Consultation Response from KC, Conservation & Design

2024/91707 21-23, 25 and 27 Round Ings Road, Outlane, Huddersfield, HD3 3FQ

Discharge of details reserved by Condition 4. (external masonry) & 8. (bi-fold doors) of permission no. 2024/90116 for Listed Building Consent alterations and renovations to existing dwellings 21/23, 25 and 27; erection of single storey extensions to existing dwellings 25 and 27; partial dismantling and re-building of detached barn; conversion and extension of detached and attached barns to form one dwelling; widening/improvements to existing access road, formation of parking and turning areas, together with hard and soft landscaping

Date Responded: 9.8.2024

side elevation - north east

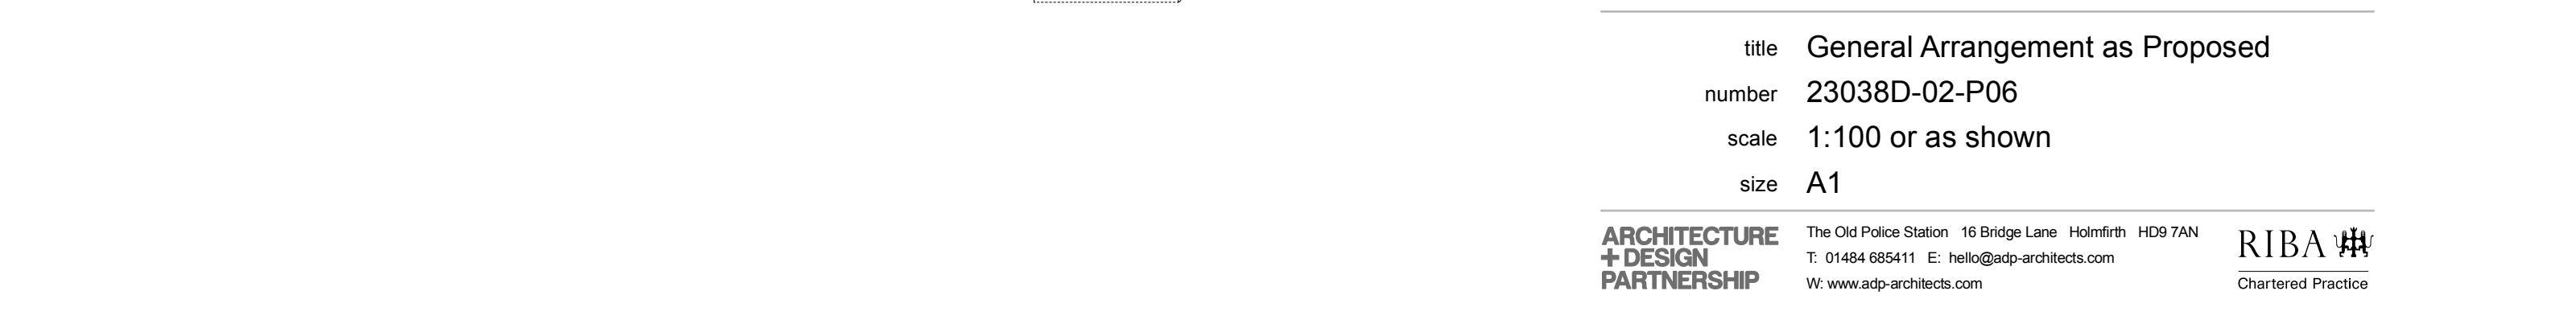
The sample panel photograph submitted on 8th August, the mix and specification submitted as an annotation on drawing 23038D-02-P06, and a mixing method, have been submitted. These are acceptable to discharge this condition.

title Bifold Door Details
number 23038D-07-P02
scale 1:20 and 1:2
size A2

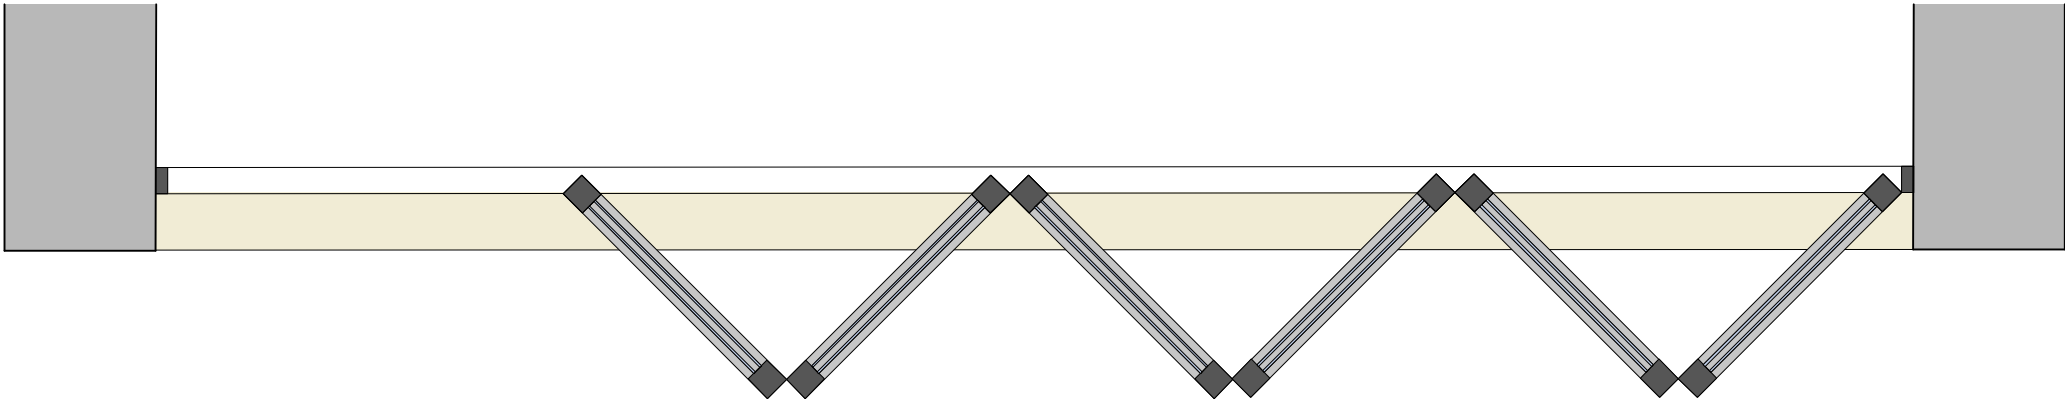
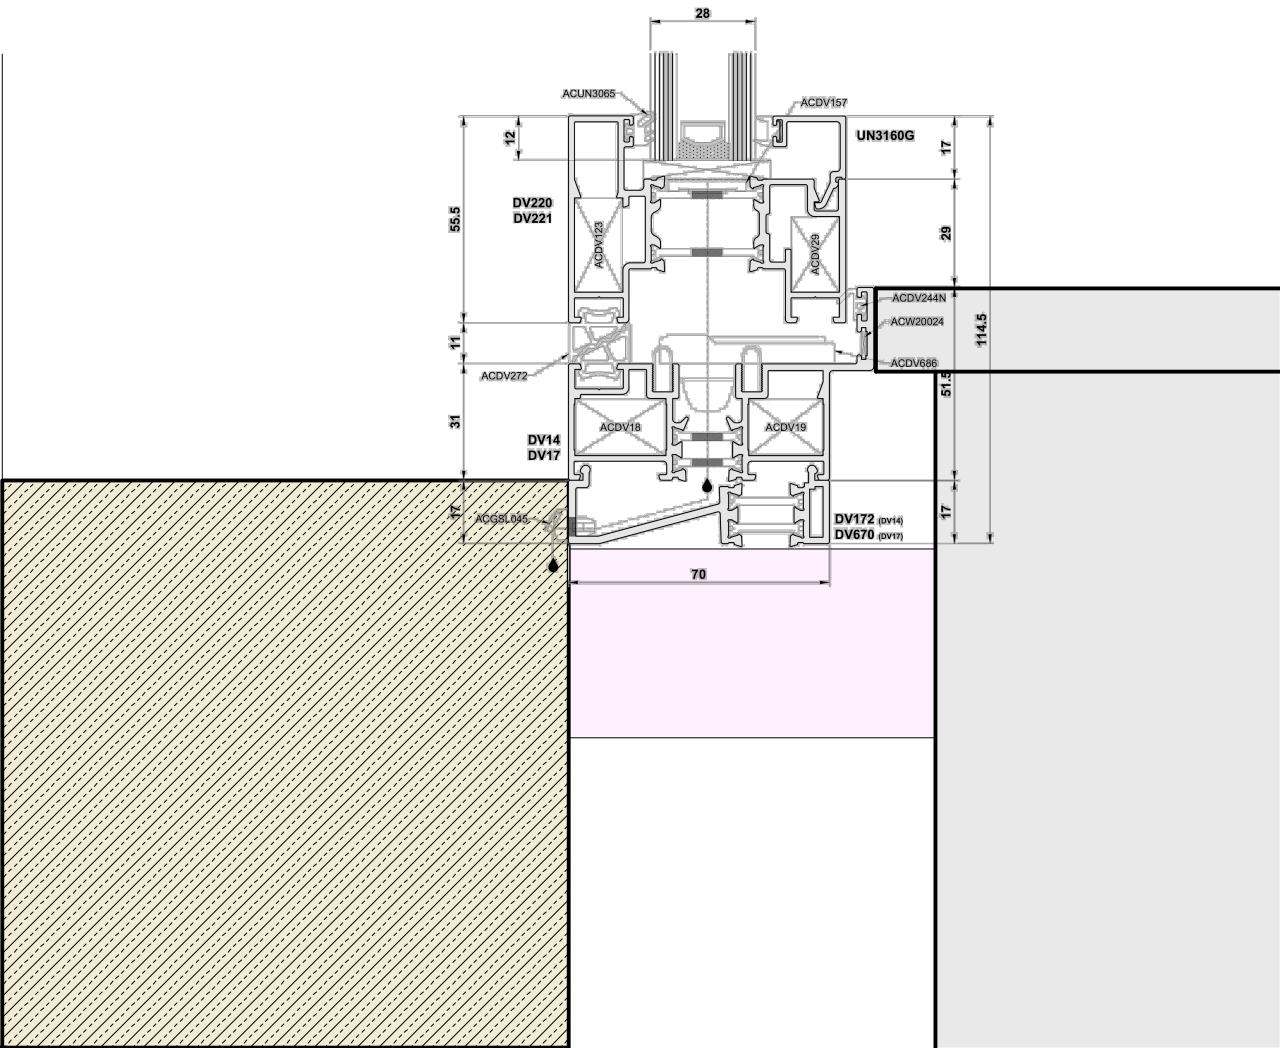
A drawing and specification of aluminium bi-fold doors has been submitted and is acceptable to discharge this condition.
